**Our Case Number:** ABP-314597-22

**Re:** BusConnects Galway Cross-City Link Scheme.  
University Road to Dublin Road, Galway City.

**Our Ref:** 210745  
**Your Ref:** ABP-314597

**Re: Submission to the BusConnects Galway: Cross-City Link (University Road to Dublin Road) Scheme**

Role	Transport Infrastructure
Suitability	Planning
Arup Job No	253352-00
Name	BCG-GA-00-07
Rev	PL01

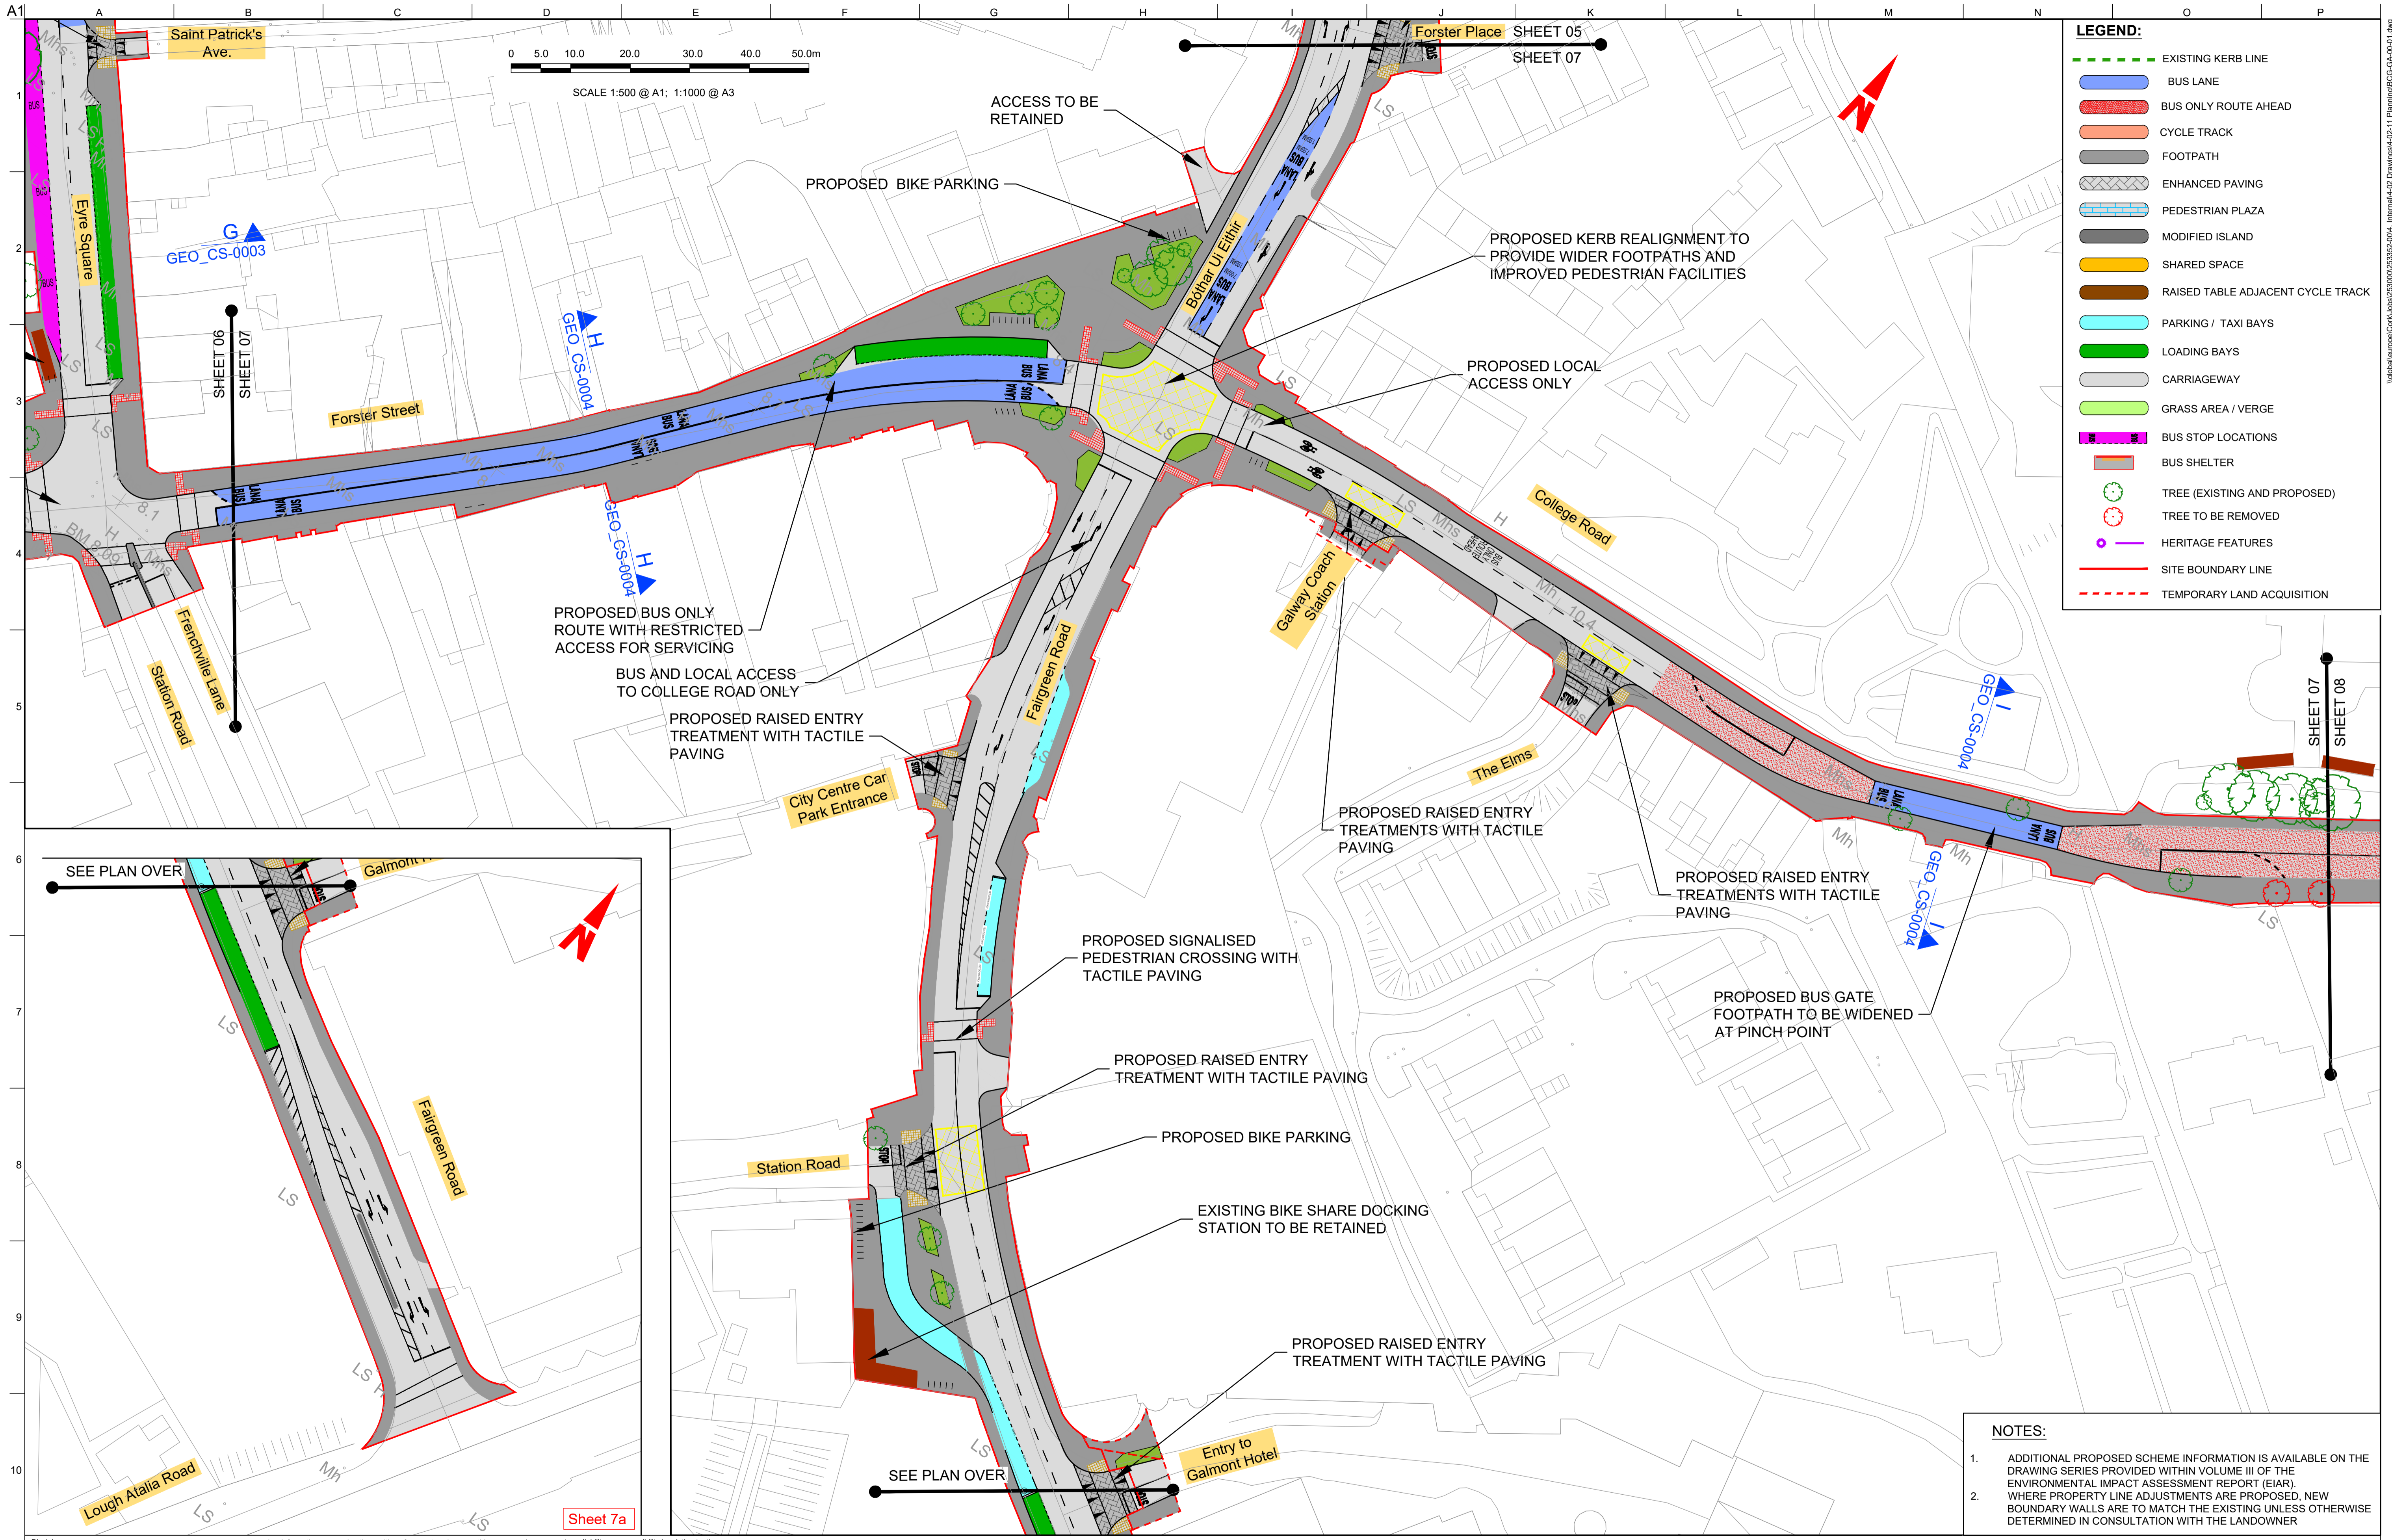
Forster Street currently benefits from an existing loading bay located approximately 50 metres northeast of the junction at Forster Street and Eyre Square. As part of the BusConnects proposal, this loading bay will be relocated approximately 50 metres northeast of where it is currently located, towards the junction at Fairgreen Road. It is also noted that the existing taxi rank at Eyre Square east is to become a shared taxi rank and loading bay. As part of the proposed road development Forster Street is to be occupied by a two-way bus lane system between 7am -10am and 1pm – 7pm. An overview of the proposed roads arrangement is provided in **Figure 1** below.

The removal of the existing loading bay currently located adjacent to An Púcán (see Figure 2) has the potential to impact upon the viability of businesses along Forster Street. This loading bay is crucial for businesses from an operational perspective, and it is therefore respectfully requested that this loading bay is retained in its current location following a grant of permission by way of planning condition.

Additionally, Connacht Hospitality Group have concerns with regard to the proposed two-way bus lane system that is proposed along Forster Street. It is respectfully requested that a one-way lane is applied with a stop-go approach on Forster Street, as opposed to the proposed two-way system.

In the event that the Board decide to grant permission for the proposed road development, it is respectfully requested that a condition is applied to the grant of permission to facilitate service vehicles and emergency vehicles access to Forster Street at all times. Our client welcomes the proposal to remove private car access from Forster Street in the interest of promoting sustainable modes of transport within the city centre area. It is crucial that the functionality of businesses is protected in tandem with the provision of sustainable transport measures, and it is considered that appropriate access for service and emergency vehicles is fundamental to the operation of businesses in the city centre area. It is considered that access for these vehicles will not diminish the overall objective to promote sustainable transport modes in Galway city centre.
